From: Sharon Chlouk [REDACTED]
Sent: 16 November 2020 15:19
To: Planning.Responses <Planning.Responses@arun.gov.uk>; Hamadi Chlouk [REDACTED]
mrsagardner@arun.gov.uk
Subject: Previous Representation on: FG/29/20/PL at Onslow Caravan Park - Now representing for: FG/127/20/PL

Further to my email below dated 7th April, 2020, I would like to re-submit my objection to the 'retrospective' application for the demolition of 3 No. existing buildings & erection of replacement workshop & machinery store building (amended design & siting to FG/37/17/PL).

Floor Plan & Elevations Drawings provided by and copyright Stephen Jupp

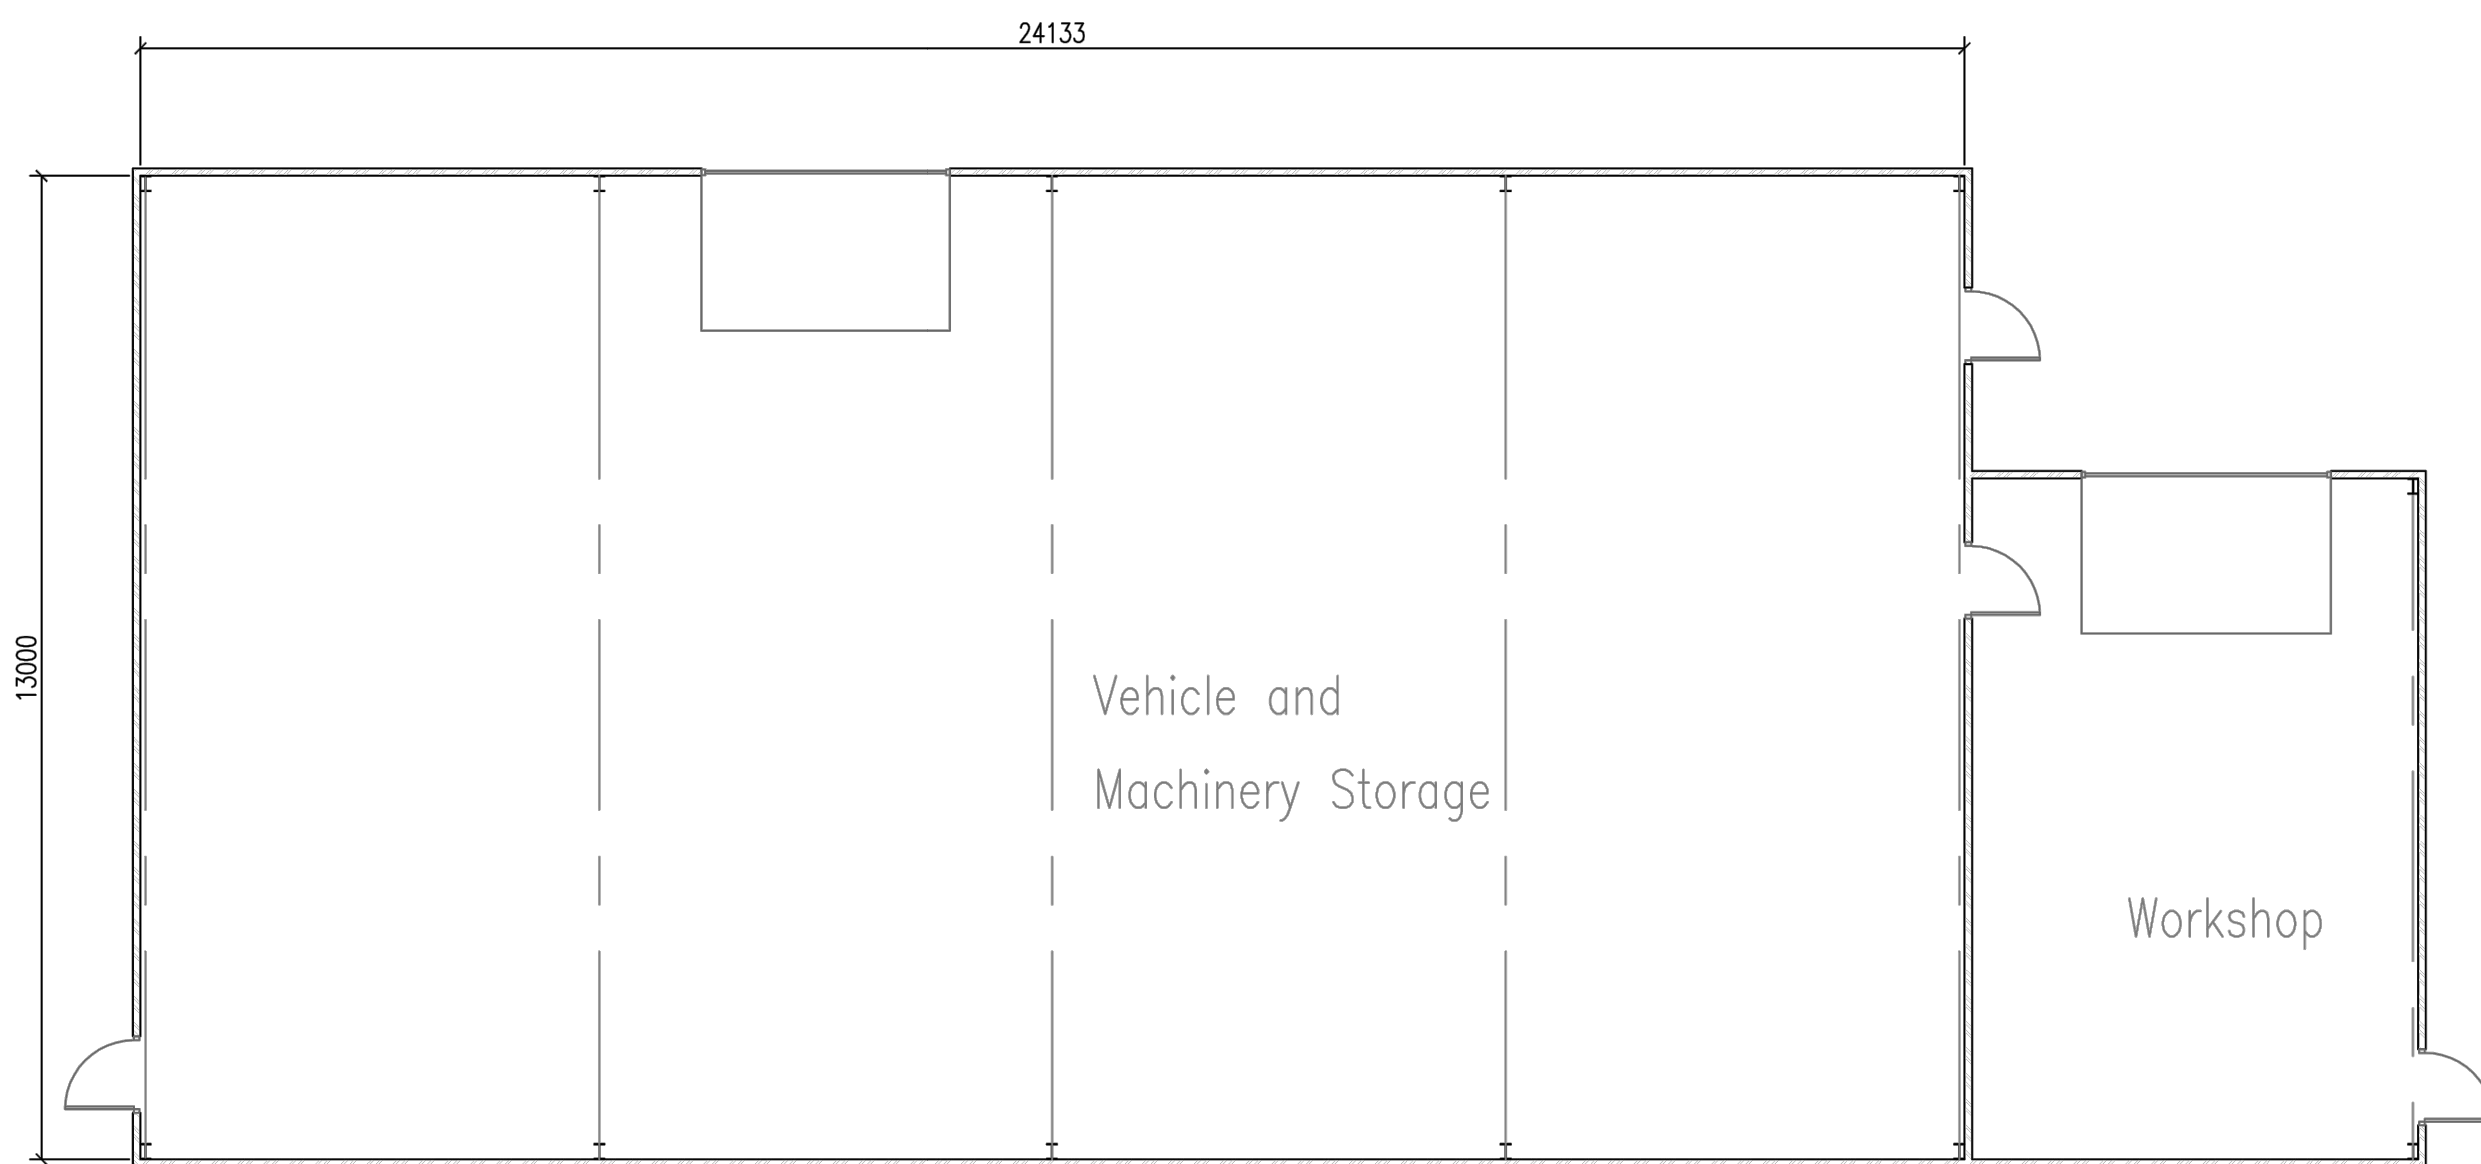
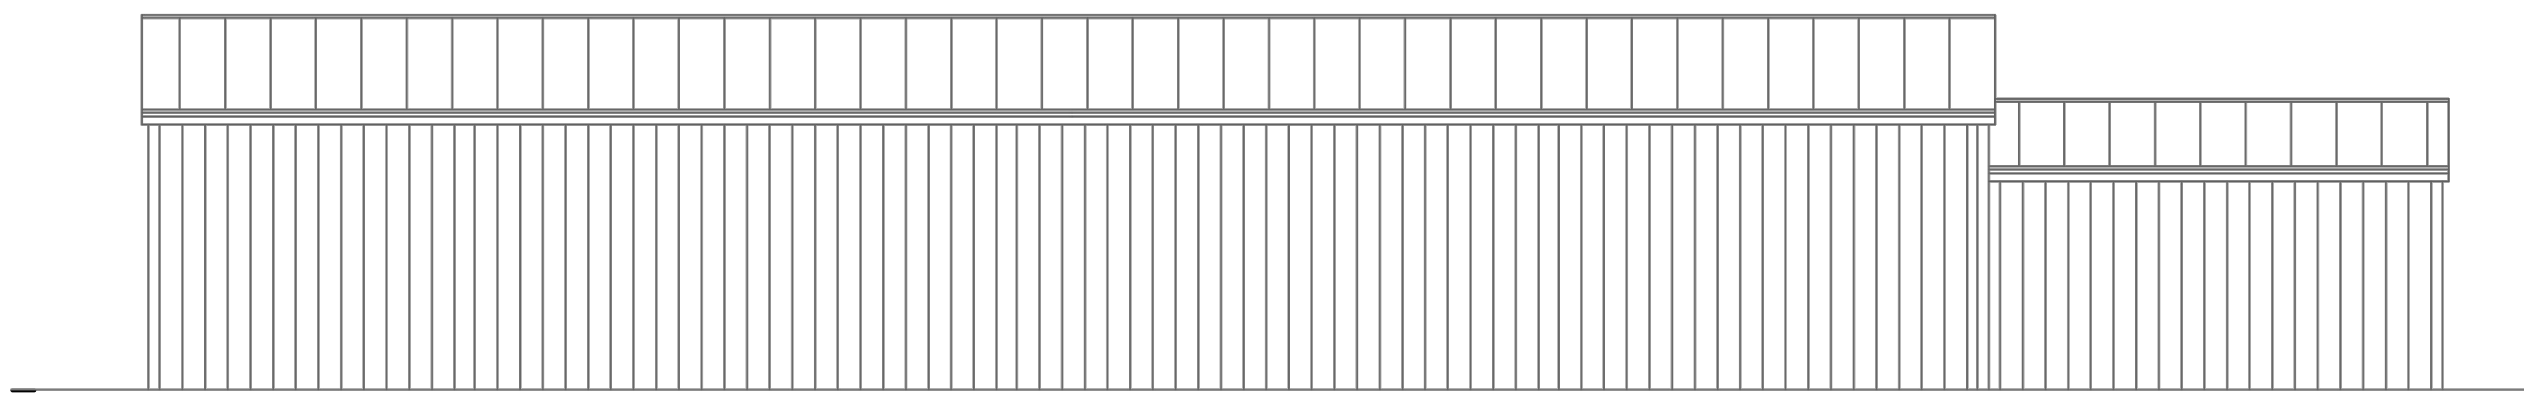
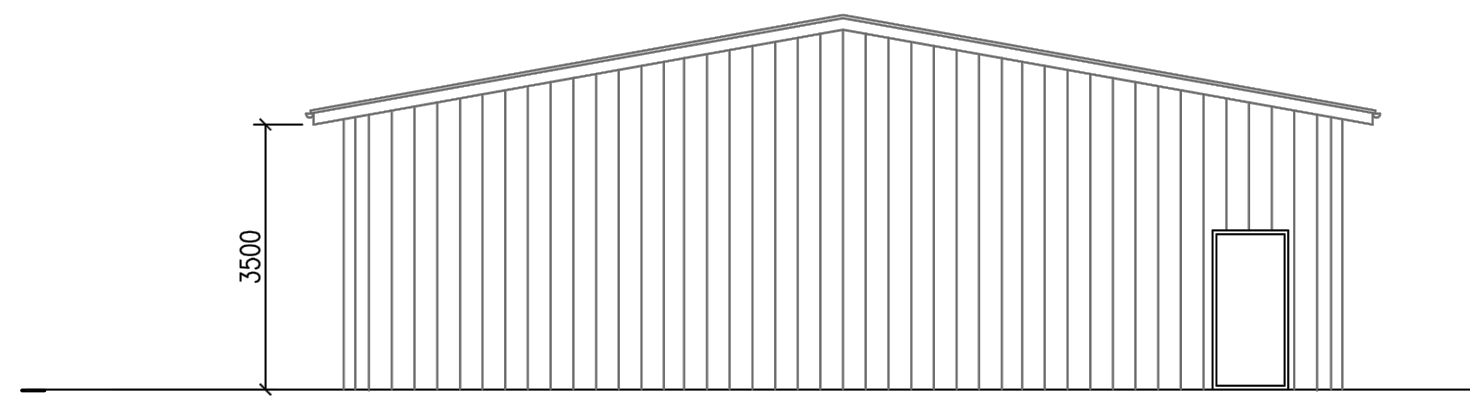
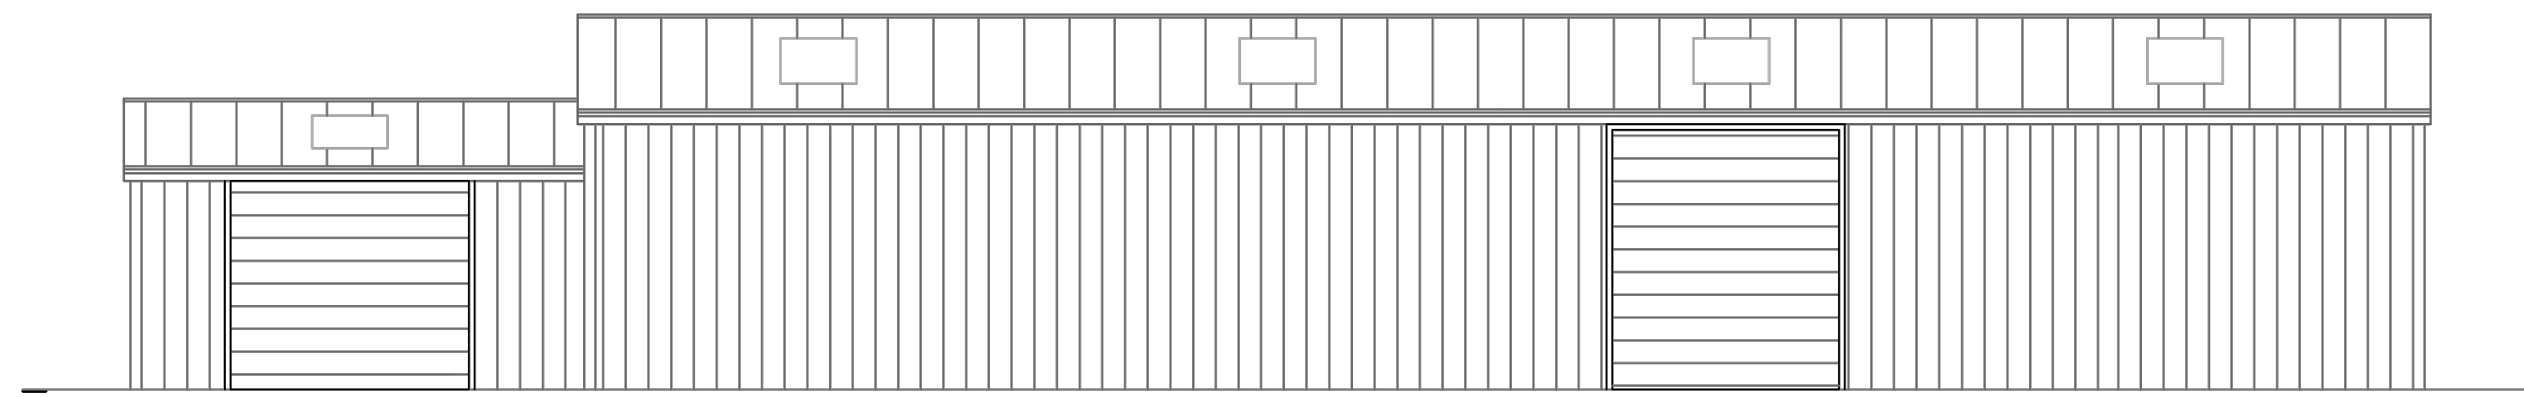
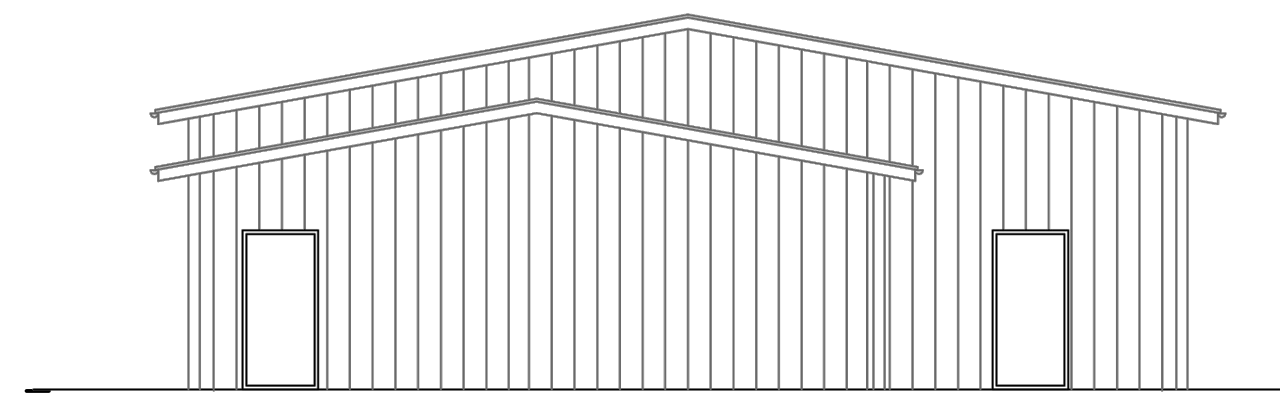
I note that at no stage has the height of the current structure been reduced since it was erected to give us our beautiful view of the South Downs back. This building is not compliant with the original plans and therefore the building should have never been allowed to be built to the stage it is now.

*We are appalled to see a new planning request go up with a suggestion of '**proposed elevations & roof plan**'. If the roof is elevated, it will make an already dark back bedroom and garden even darker!*

SHADOW STUDY

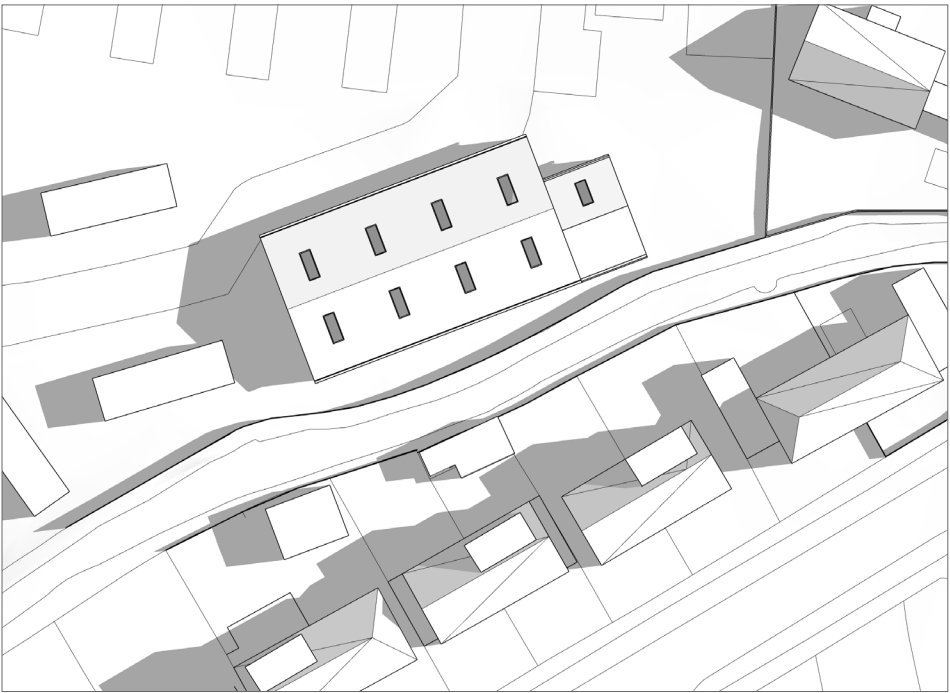
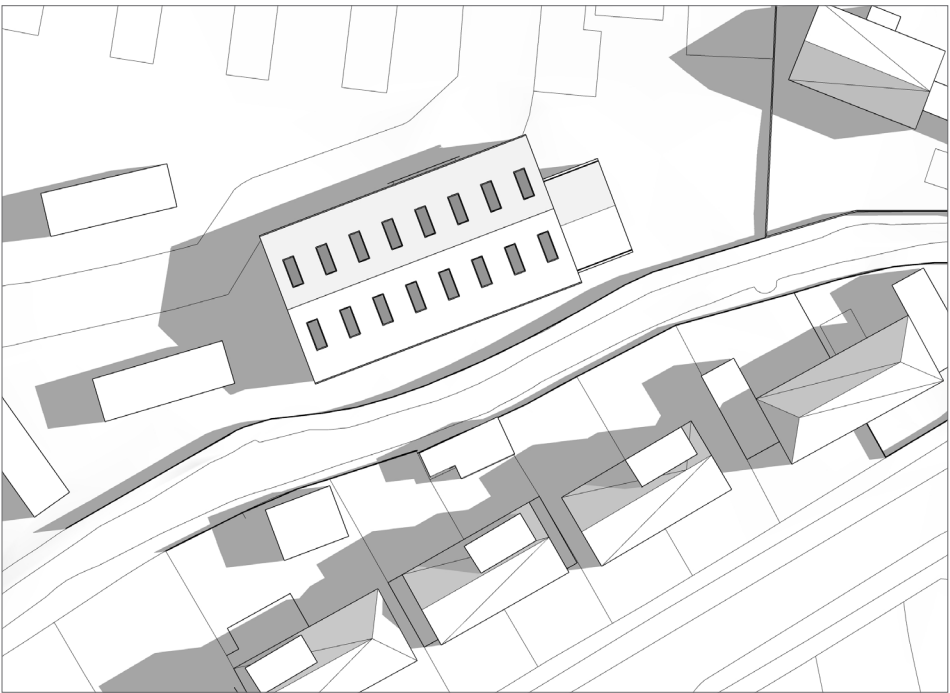
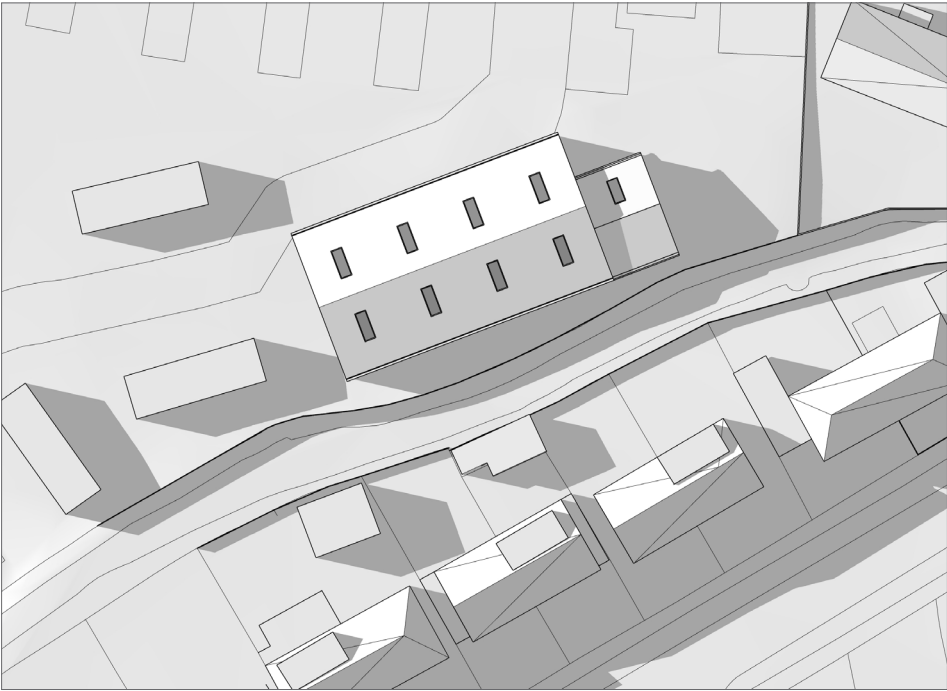
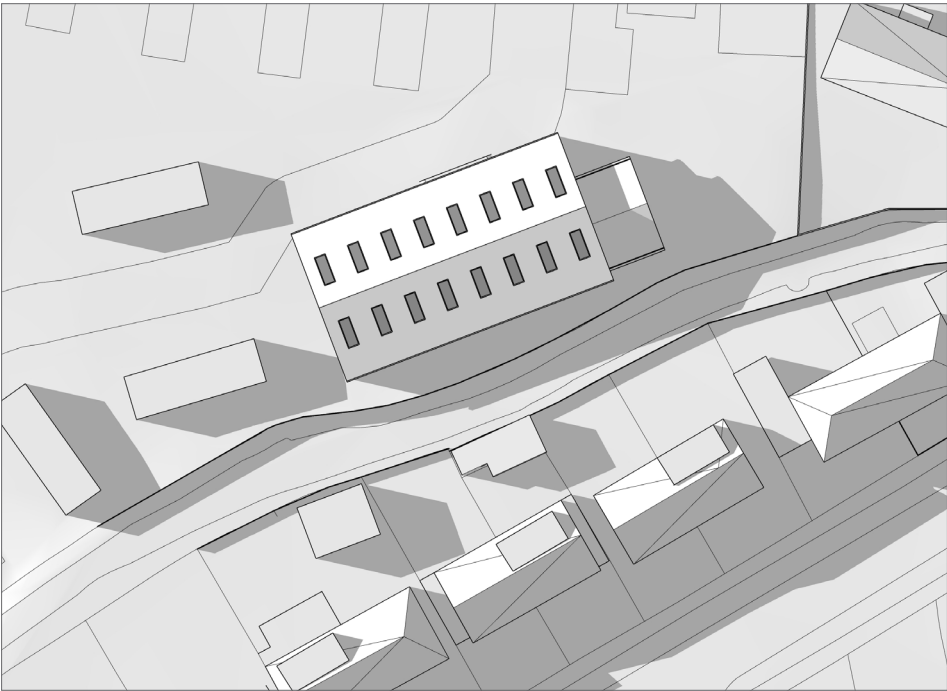
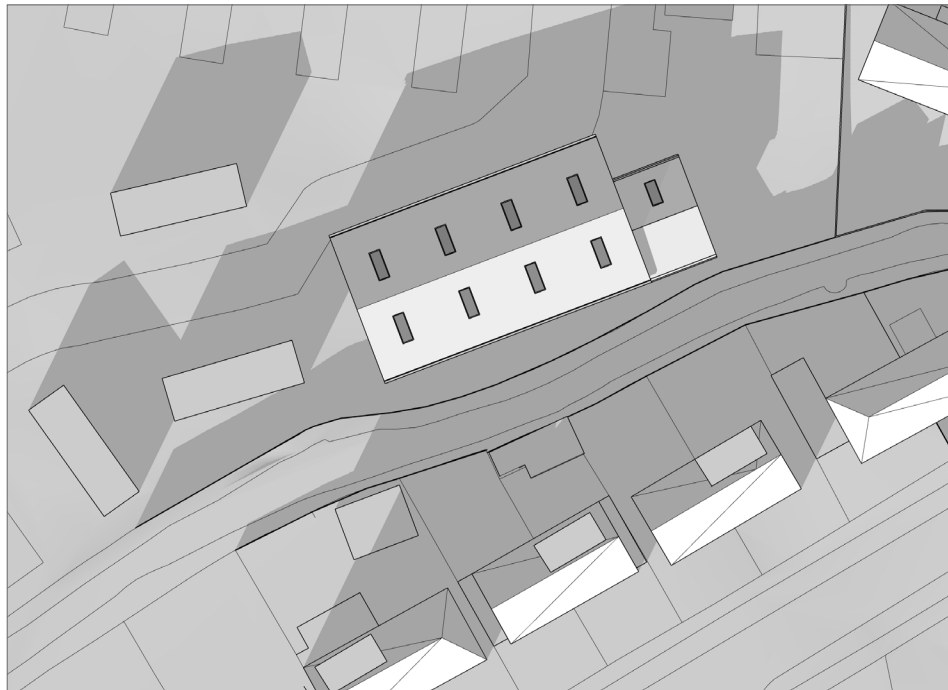
This used to be a pretty, well maintained caravan park at the back of our home, where, for the last 28 years we have had no issues with whatsoever (apart from the removal of the trees which amounts to a large loss of habitat for the local avian populations, the trees also gave us adequate privacy and seclusion from the site). Unfortunately, you decided to grant the building to go ahead in their grounds which now obliterates the beautiful view we had of High Down Hill and the South Downs. The building also blocks out any evening sun we lucky to enjoy in our North facing back garden. This structure now effects 5-6 of our neighbours' homes in Meadow Way, Ferring.
